**KIRKLEES METROPOLITAN COUNCIL
INVESTMENT & REGENERATION SERVICE**

DELEGATED DECISION TO DETERMINE PLANNING APPLICATIONS

Reference No:	2026/62/90544/W
Site Address:	adj, 42, New Street, Huddersfield, HD1 2BU
Description:	Installation of 1 BT Street Hub, incorporating 2 digital 75inch LCD advert screens, and associated BT Phone Kiosk removal (within a Conservation Area)
Recommending Officer:	John Holmes

DECISION - REFUSED

Drg Status PLANNING	
Cell No. & Name HUD-05	
Site Name & Address Pavement o/s 42 New Street, Huddersfield, HD1 2BU	
Drawing Title EXISTING AND PROPOSED ELEVATIONS

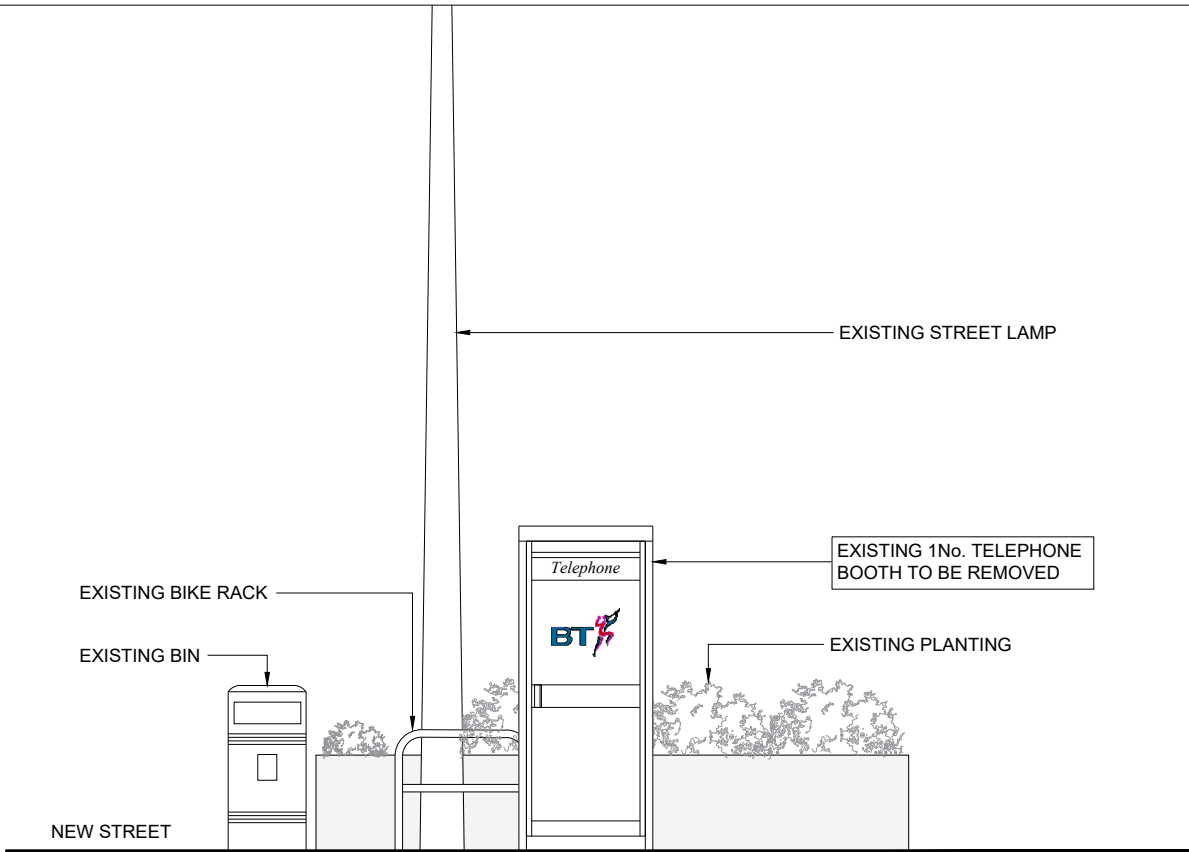
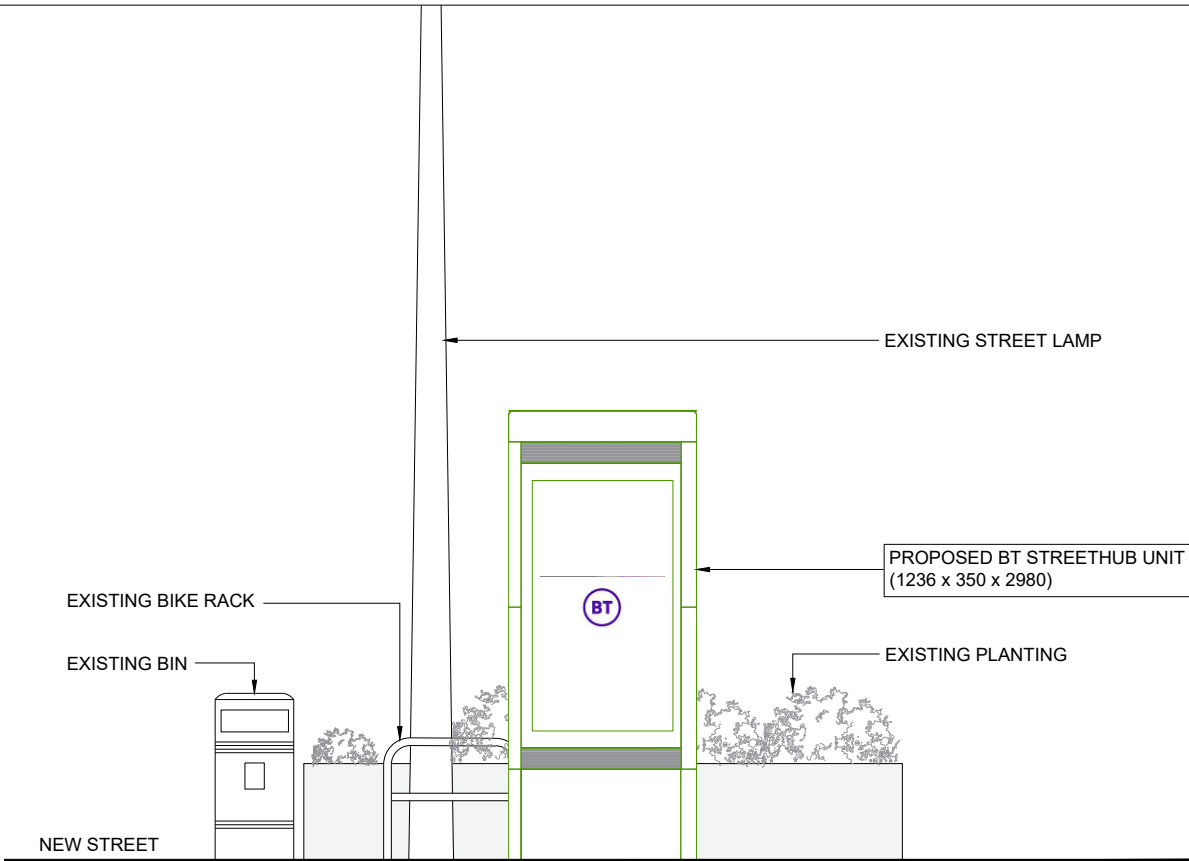
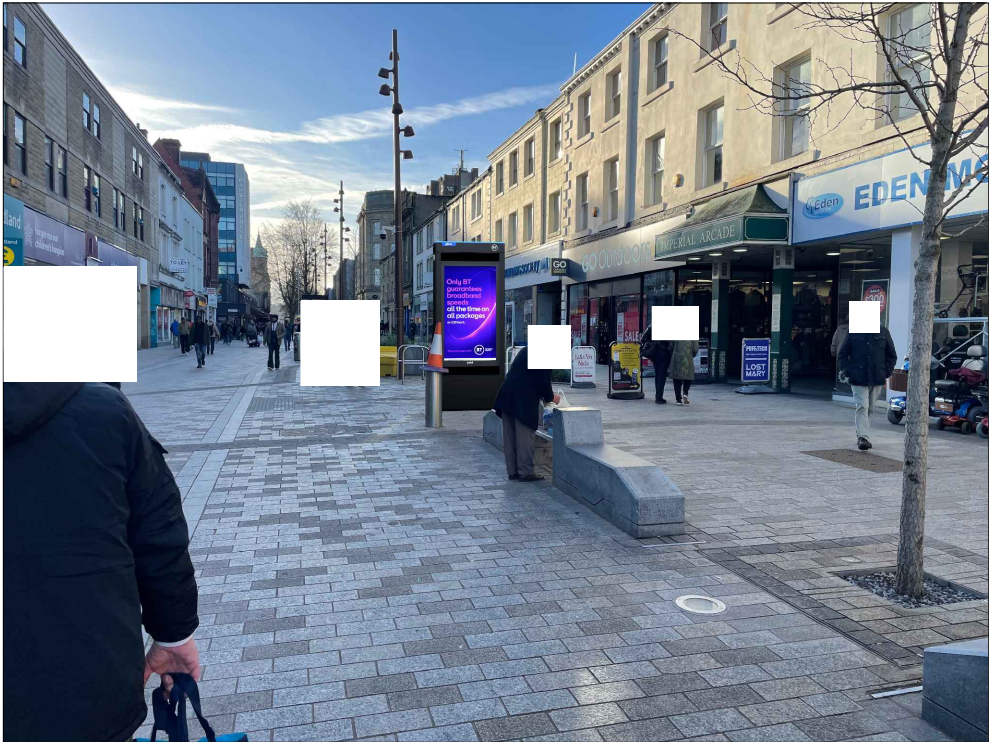
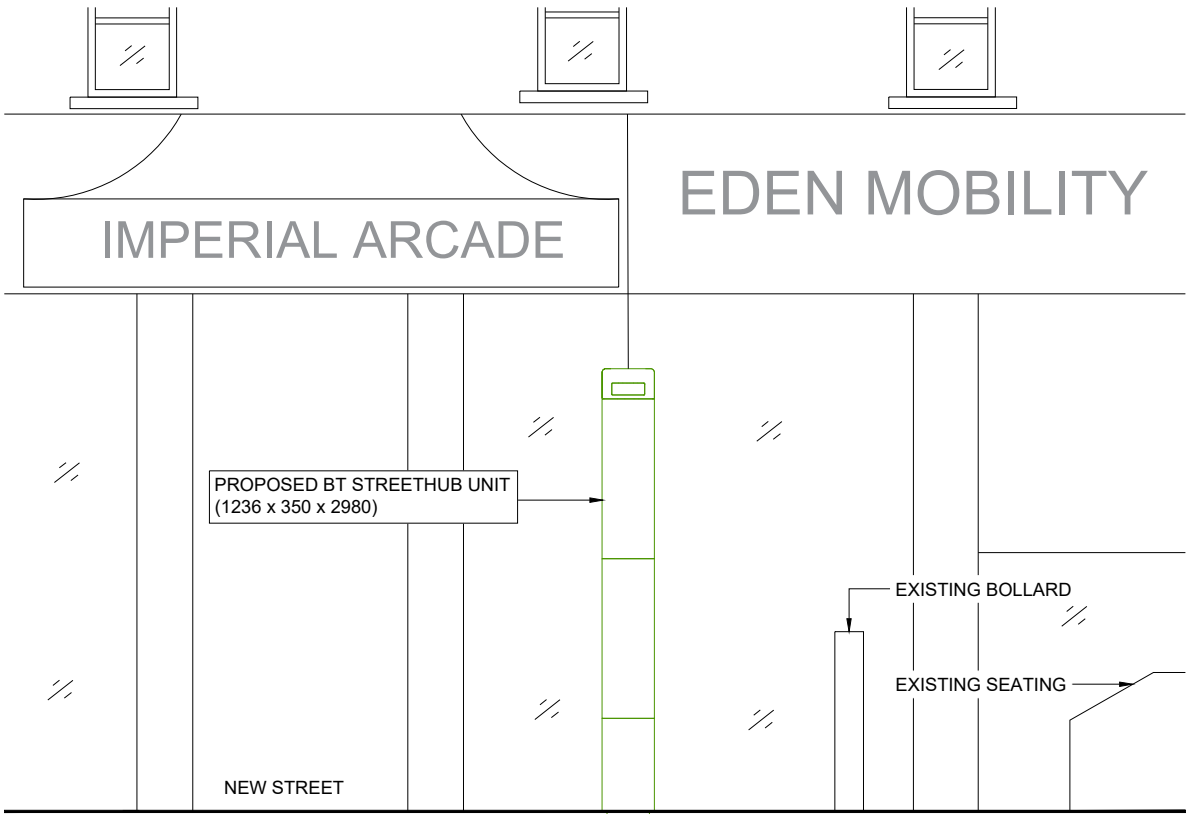
The proposed Street Hub would have a similar footprint, although is a more rectangular rather than square footprint. The Street Hub would be 3m high, sited in a prominent location on the footway. This prominence would be compounded by the illuminated digital illuminated displays on each side of the structure. This would make it a visually intrusive feature, out of character of its surroundings.

A separate application has been made for consent to display an advertisement, but the proposed screens are an essential part of the Hub, as the supporting documents make clear, and the two cannot be considered in isolation from each other. It is considered that the proposed development would not preserve or enhance the character of the Huddersfield Town Centre Conservation Area, as publicised. The impact on the setting of listed buildings is also considered. The proposal would have an increased prominence and impact than the call box it replaces particularly when taking account of the illumination and this impact.

The proposed Street Hub would include illuminated screens on both sides. These are an integral part of the development under consideration, as set out in paragraph 2.2 of the Planning Supporting Statement. The proposed Street Hub and digital display screens, owing to their scale, prominent siting, and means of illumination, would be a visually incongruous and intrusive feature that would cause harm to the significance of the adjacent Huddersfield Town Centre Conservation Area, in which there are several listed buildings close by. The public benefits associated with the proposed development would not outweigh the less than substantial harm caused to the significance of the Conservation Area. In addition, the proposal would add further illuminated street clutter which would detract from the character of the wider Town Centre, and would prejudice the aims of the Huddersfield Blueprint, a ten-year regeneration initiative to rejuvenate the Town Centre and enhance public spaces. The proposal is therefore contrary to Policies LP17(a), LP24(a), and LP35 of the Kirklees Local Plan, Chapters 12 and 16 of the NPPF and Section 72 of the Planning (Listed Buildings and Conservation Areas) Act 1990.
